From: Molly Storer
Sent: 25 April 2025 08:37
To: DC Admin
Subject: FW: URGENT Planning Application No. 2024/62/93017/W Alleged breach: 51, Longcroft, Almondbury, Huddersfield, HD5 8XW)

Subject: URGENT Planning Application No. 2024/62/93017/W Alleged breach: 51, Longcroft, Almondbury, Huddersfield, HD5 8XW)
Importance: High

Drawing No. 22102 - 0301 - P07

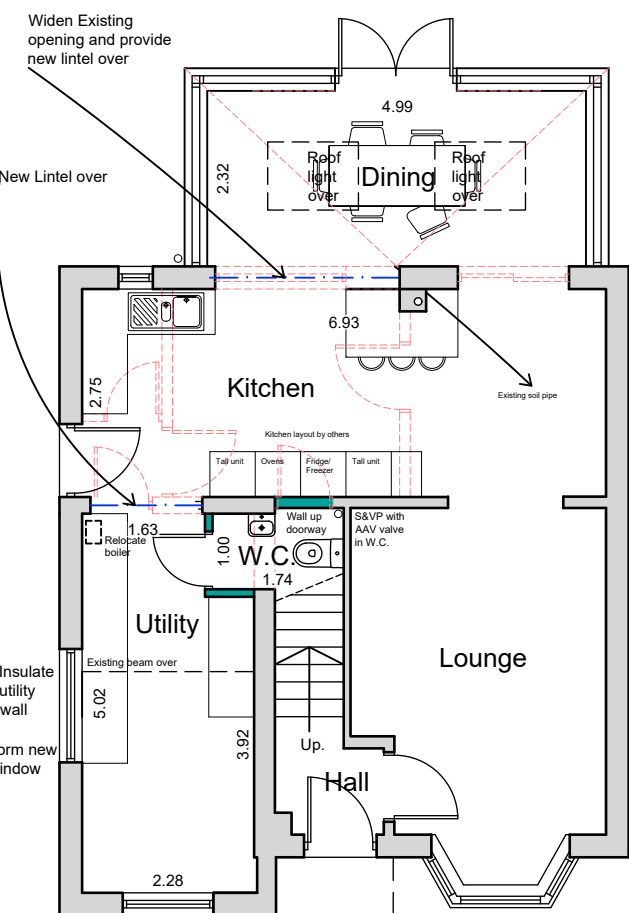
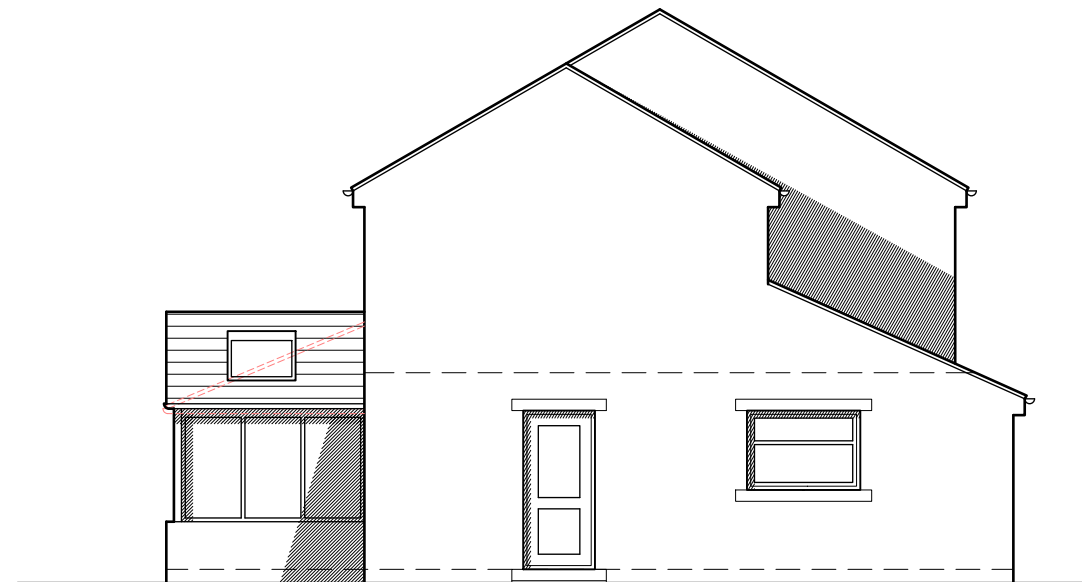
- 1) The sightlines and safety issues for road users and pedestrians have not been addressed, remain a safety concern and if fence remains, even with slight movement, continues to be “an accident waiting to happen.”

- 2) On reviewing the objection submitted on 16th April 2025 regarding - “The title deeds Third Schedule Covenant states- 1. No building structure or erection of any kind shall be placed or erected on the Transferred Land nearer to the road to which the same fronts than the frontage of the Premises and the space between the Premises and the said road shall be maintained as an ornamental garden or grass plot and kept in a neat and tidy condition” and 3. Forever hereafter to maintain a suitable fence wall or hedge where marked with a “T” inwards” This legally binding covenant signed and agreed to by the property owner cannot be ignored. Kirklees council and the planning office are legally obliged to inform the property owner to reinstate the original fence position and ornamental garden or grass plot.

I trust this gives you more than enough cause to refuse the illegal position of the fence at NO.51 and the request to the home owner to remove fence, reinstating original fence line as per property deeds.
